June 3, 2016

Bayside Bowl

Permit Review Comments Responses

A5-6

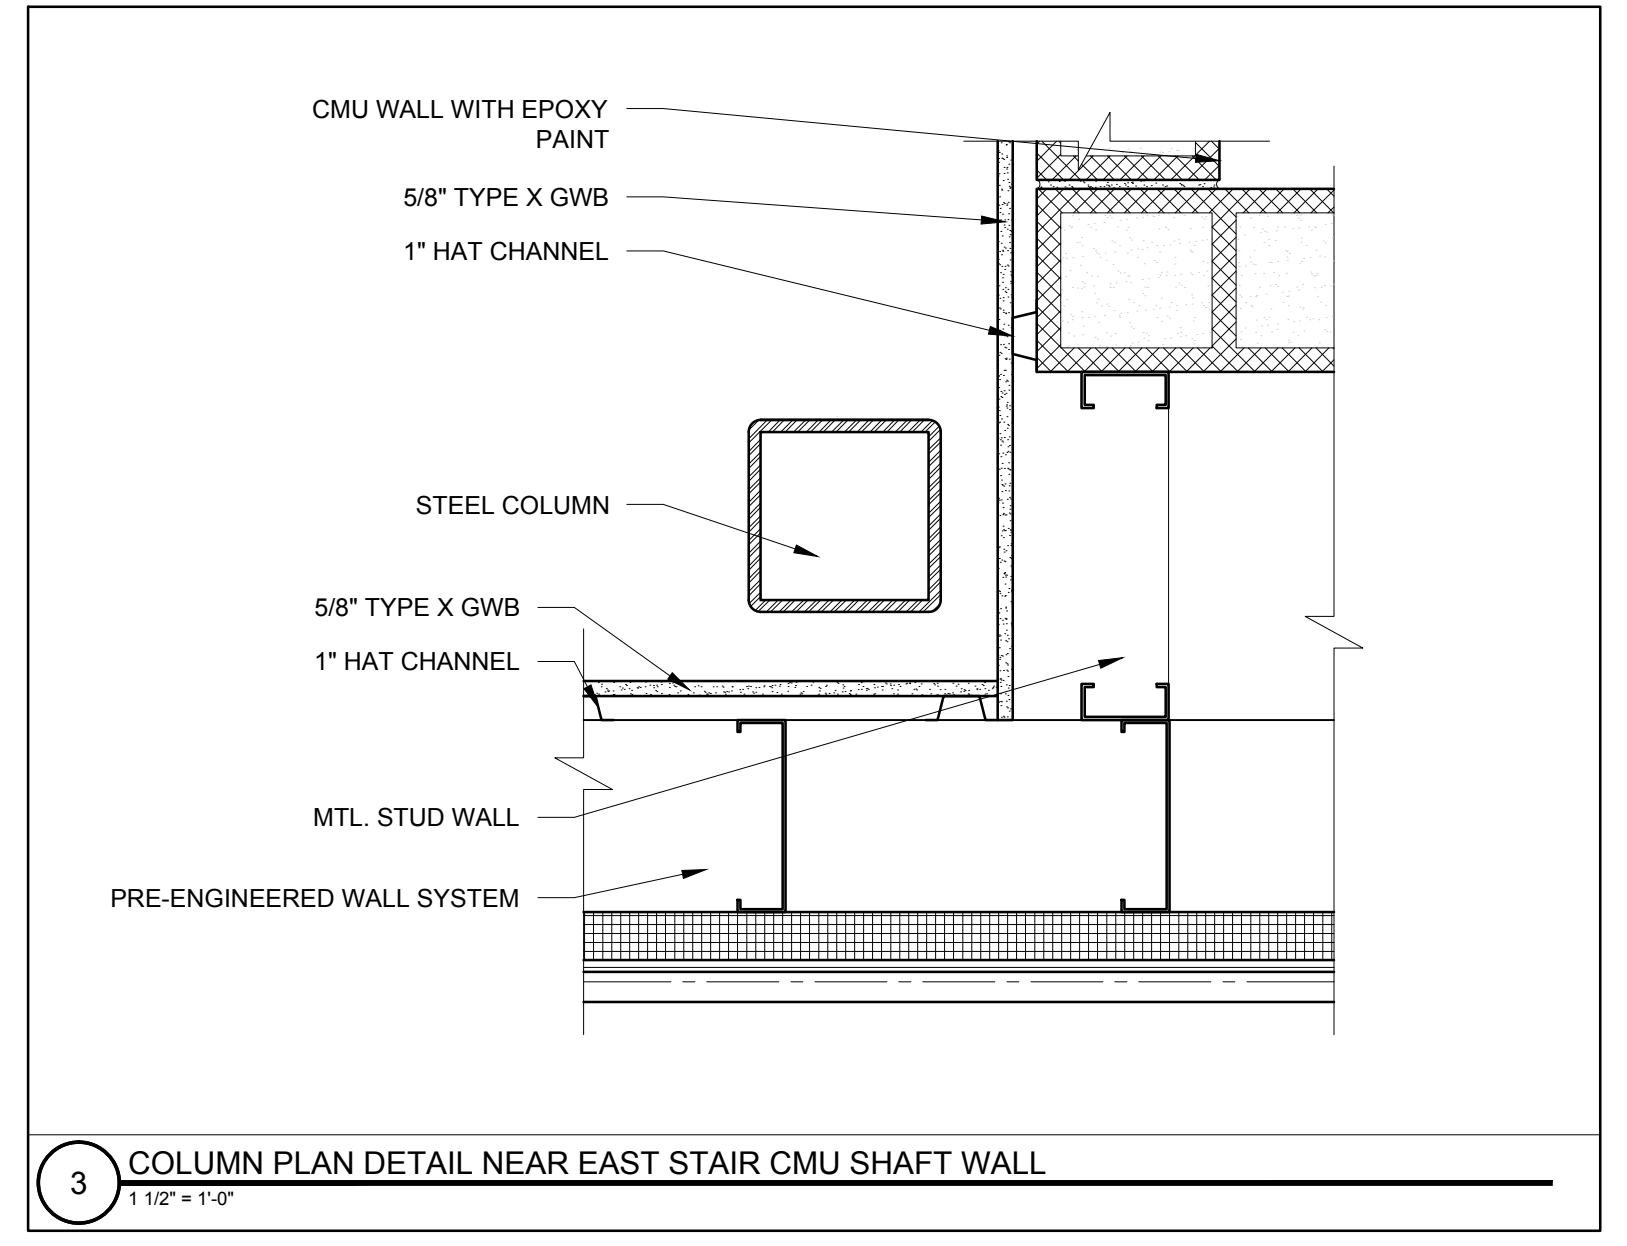
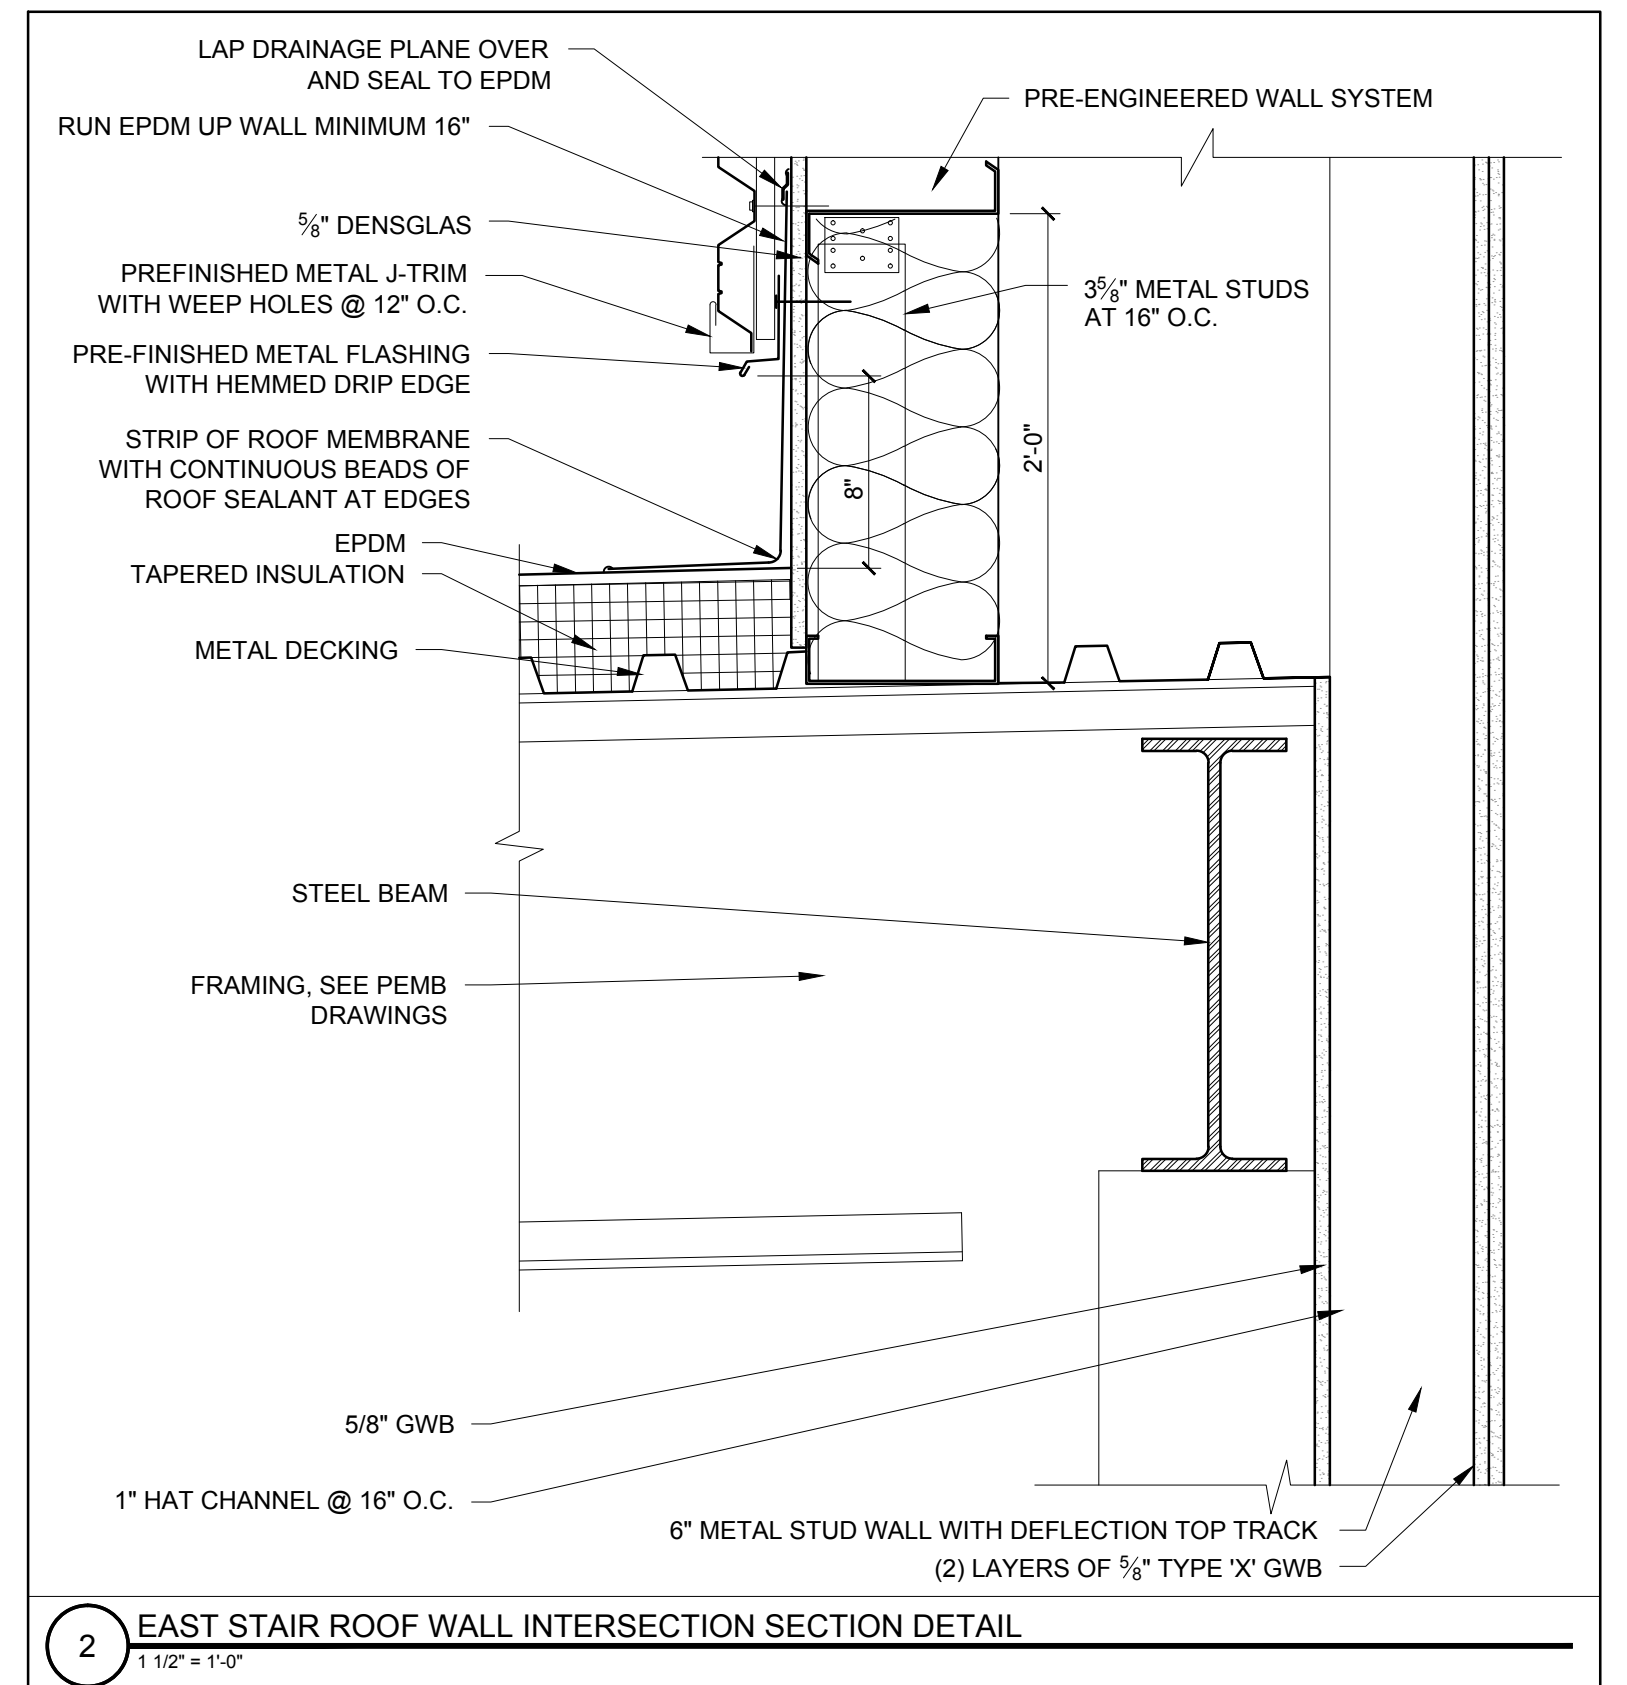
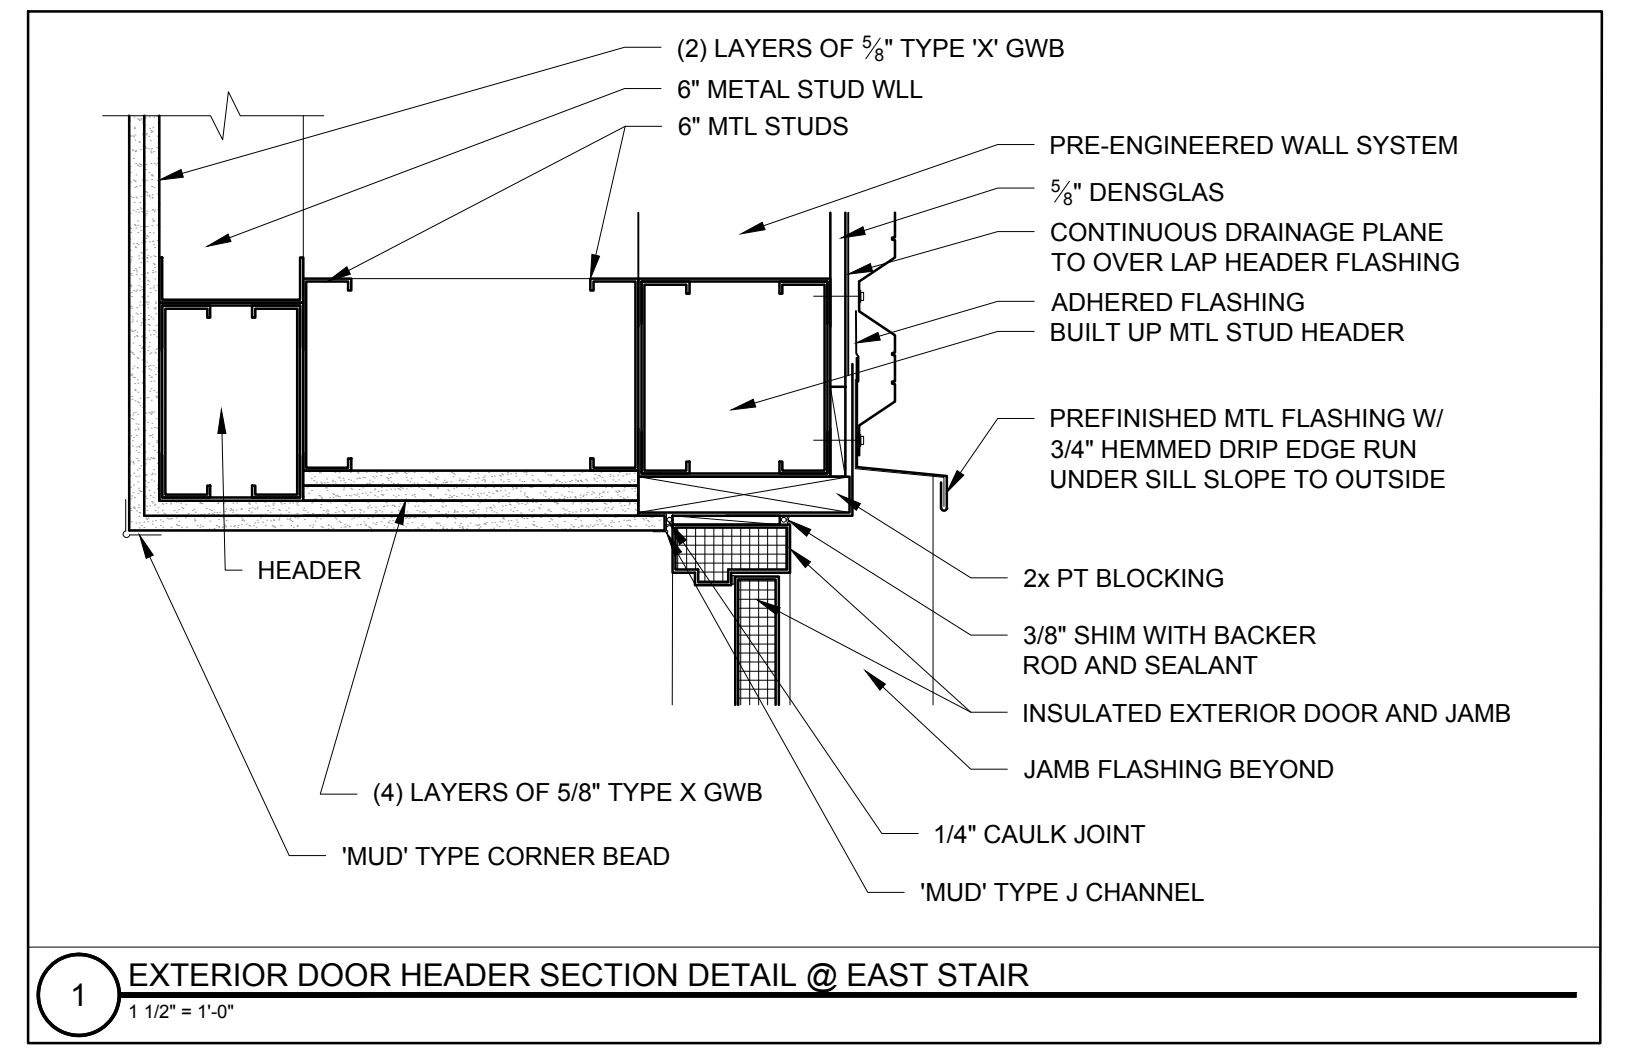
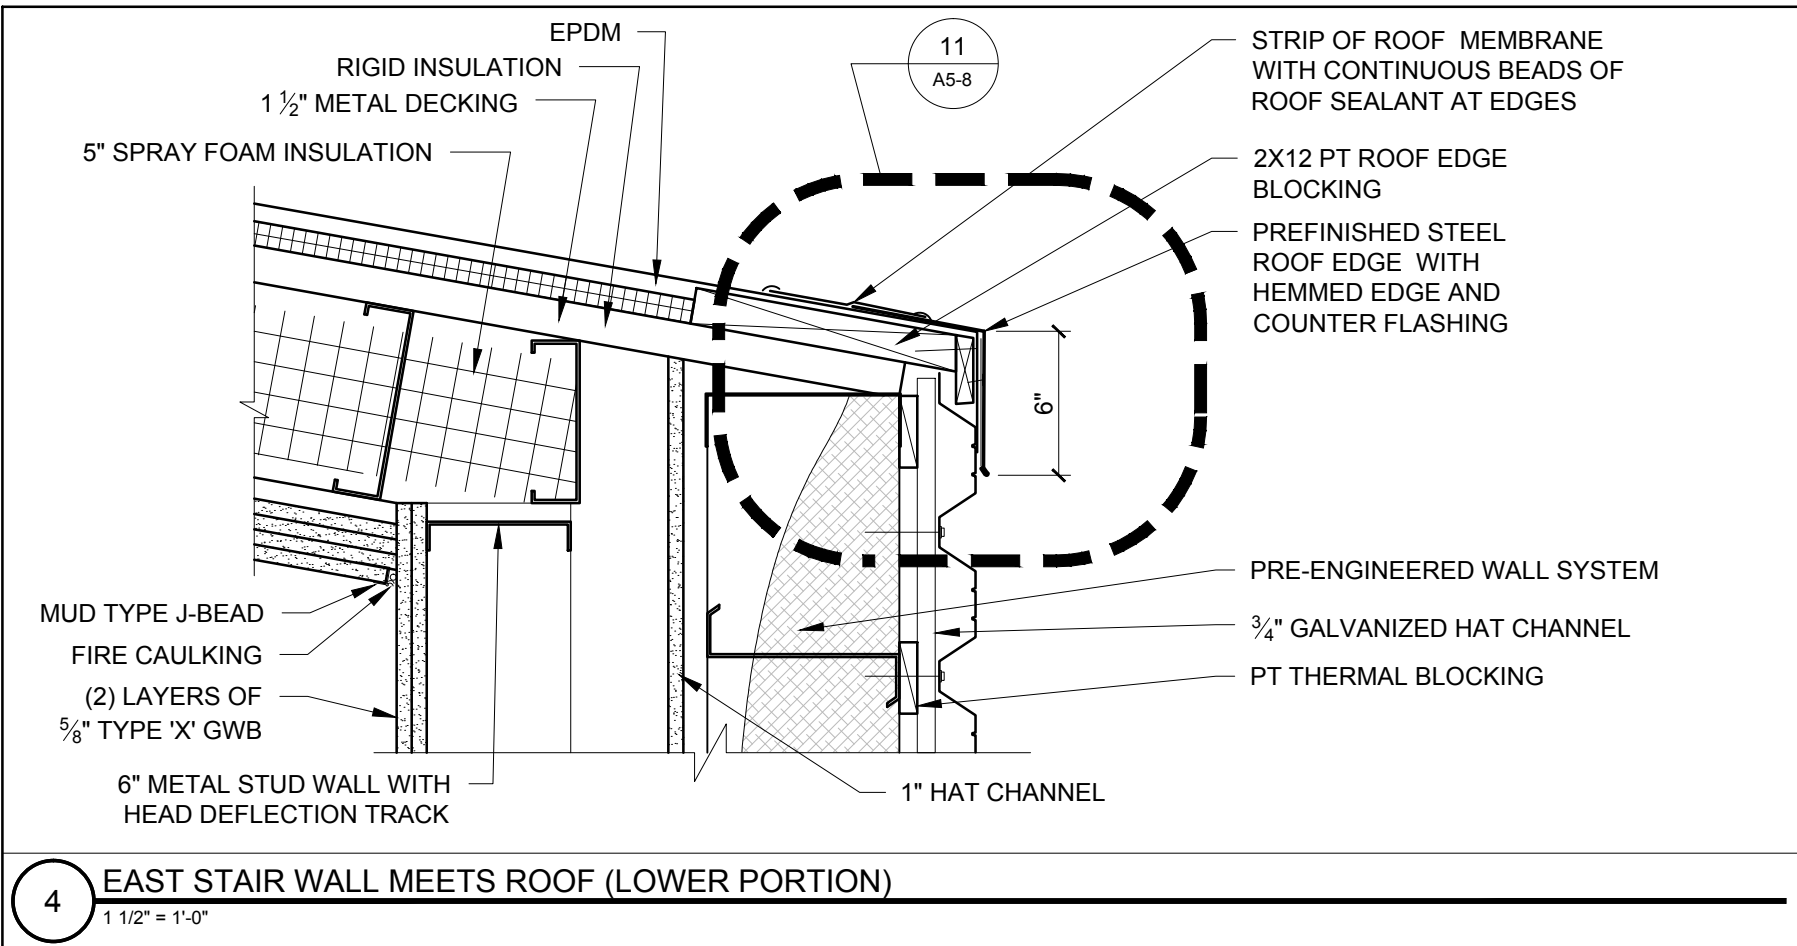
- 5.) A5-8, please see the revised sheets A5-1, A5-5, A5-6, A5-7 and A5-8 showing Fire treated roof blocking in lieu of PT blocking.
- 6.) A5-4, the detail was incorrectly tagged it is corrected as Detail 4/A5-2 on the attached sheet.
